STATE OF WASHINGTON
DEPARTMENT OF ECOLOGY

Re: SP-10-00013

Thank you for the opportunity to comment on the short subdivision of approximately 48.19 acres into 4 lots, proposed by Scott Anderson. We have reviewed the application and have the following comments.

**ANDERSON SHORT PLAT
 PART OF SECTION 33, T. 18 N., R. 19 E., W.M.
 KITITAS COUNTY, WASHINGTON**

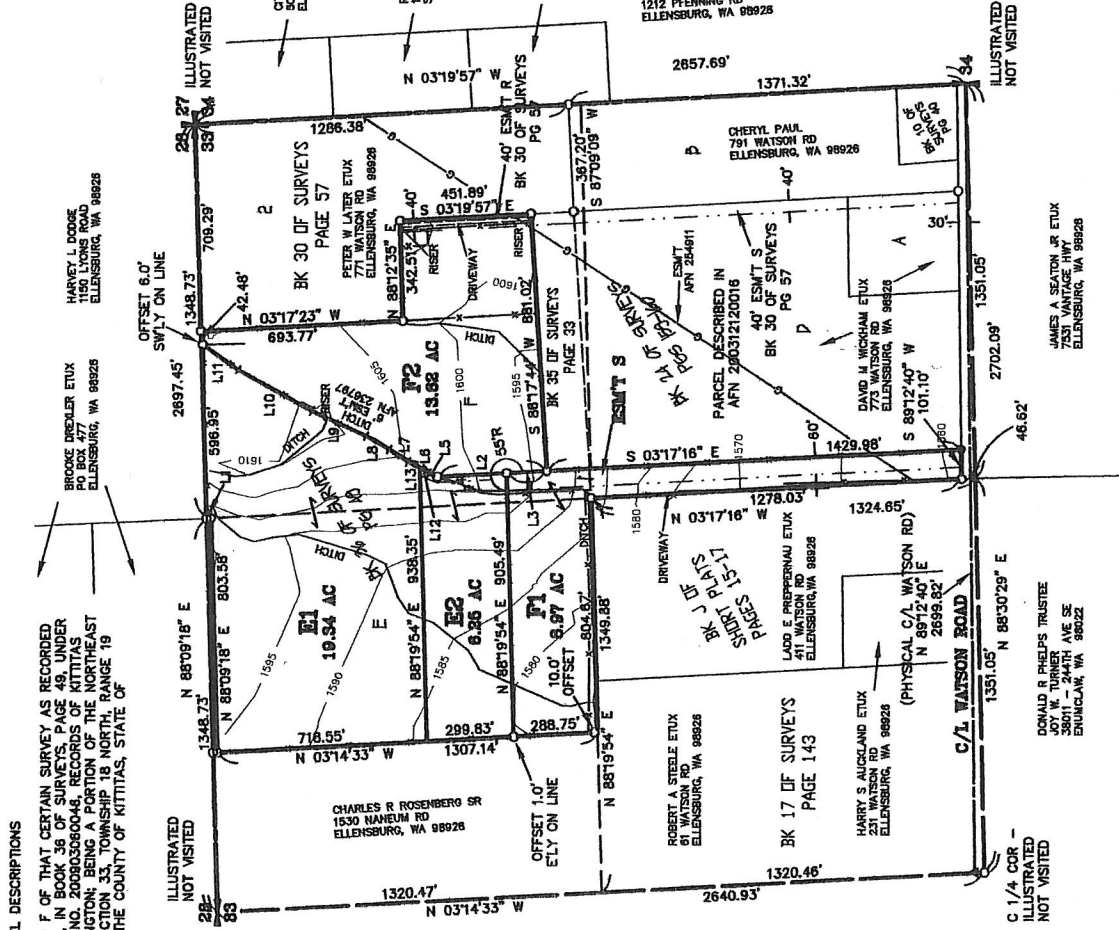
A review of aerial photos shows that the wetlands on site may be more extensive than that which is identified on the NWI map for the parcel. A wetland delineation report should be required to confirm the extent of wetlands on these parcels before the short plat is approved to assure that there is the capability of buildable area on each parcel without extensive damage to wetland areas. Ecology would be happy to assist the County with a wetland report review and/or field review to verify the accuracy of the generated wetland report.

Parcels should be configured in such a way so that access to and development of the parcels can occur without impact to the wetlands on site. If there are impacts to wetlands on site, then additional permits from Ecology or the Corps of Engineers may be required before development can occur. It appears that if a road is built within the easement to the south (which connects with Watson Road) that there could be up to half an acre of wetland impact. Other access routes to the proposed parcels should be required so that

impacts to wetlands can be avoided. It appears that there might be other options using an existing driveway to the west off Watson Road for parcel F2 and access to the other parcels from either Naneum Road or from a new driveway from the north which could be an extension of Game Farm Road.
